**WELWYN HATFIELD COUNCIL – DEVELOPMENT CONTROL  
DELEGATED REPORT**

<b>APPLICATION No:</b>	<b>S6/2010/2960/LU</b>
------------------------	------------------------

The proposal is to create a dormer window on the southern side elevation with a pitched roof.

PROPOSED SIDE ELEVATION

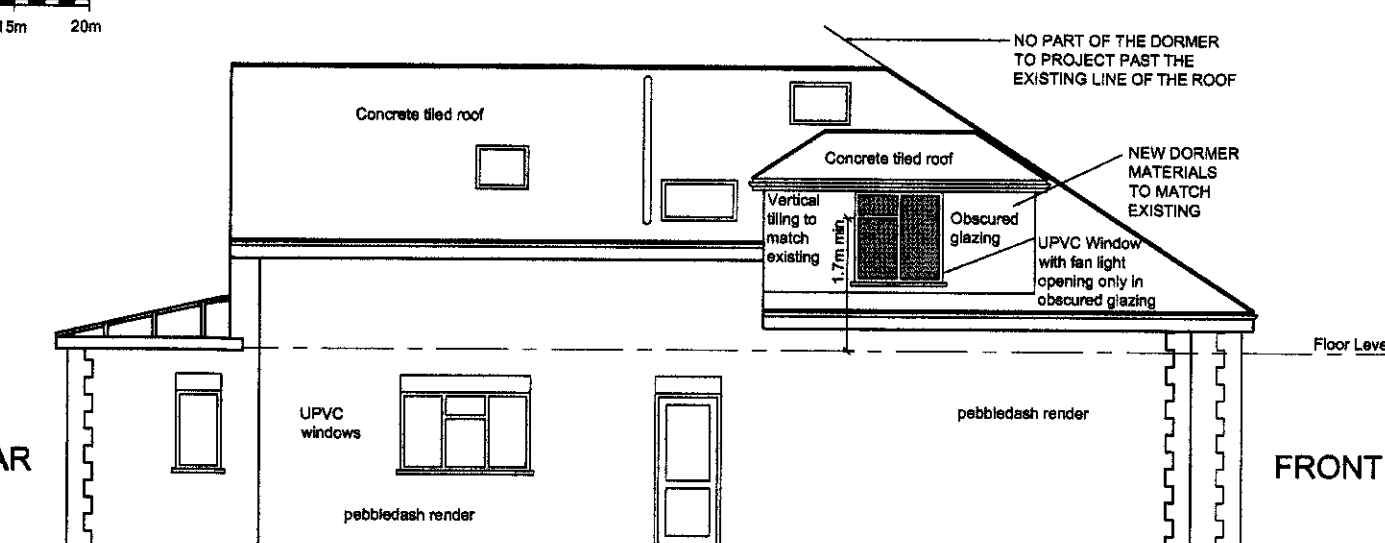
*A window is shown on the side elevation of the dormer window and is shown to be obscure glazed and non opening below 1.7 metres*

PROPOSED LOFT LAYOUT

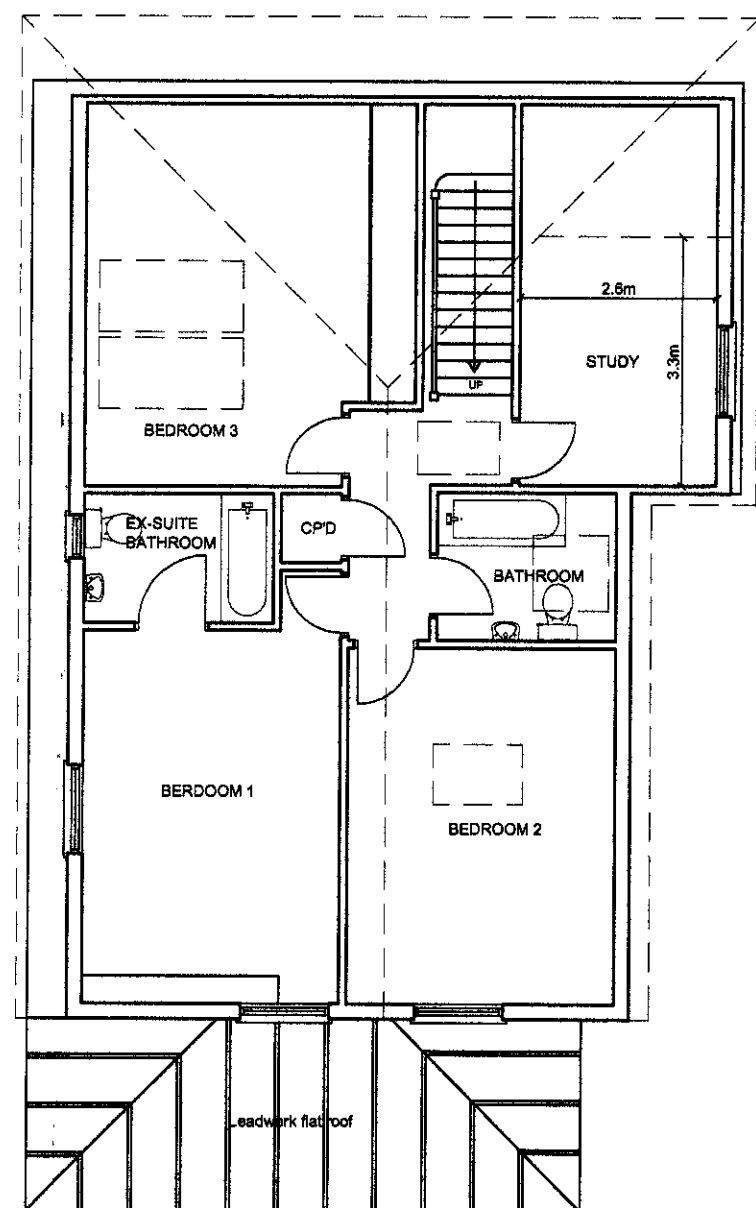
*Proposed roof dormer window:*

$$(l) 3.6m \times (h) 1.45m \times (d) 2.2m / 2 = 5.74m^3$$

$$(l) 2.2m \times (d) 2.4m \times (h) 1.95m / 2 = 4.68m^3$$

$$(l) 0.9m \times (d) 2.4m \times (h) 1.95m / 2 = 1.40m^3$$

*Total additional roofspace = **11.86m<sup>3</sup>***
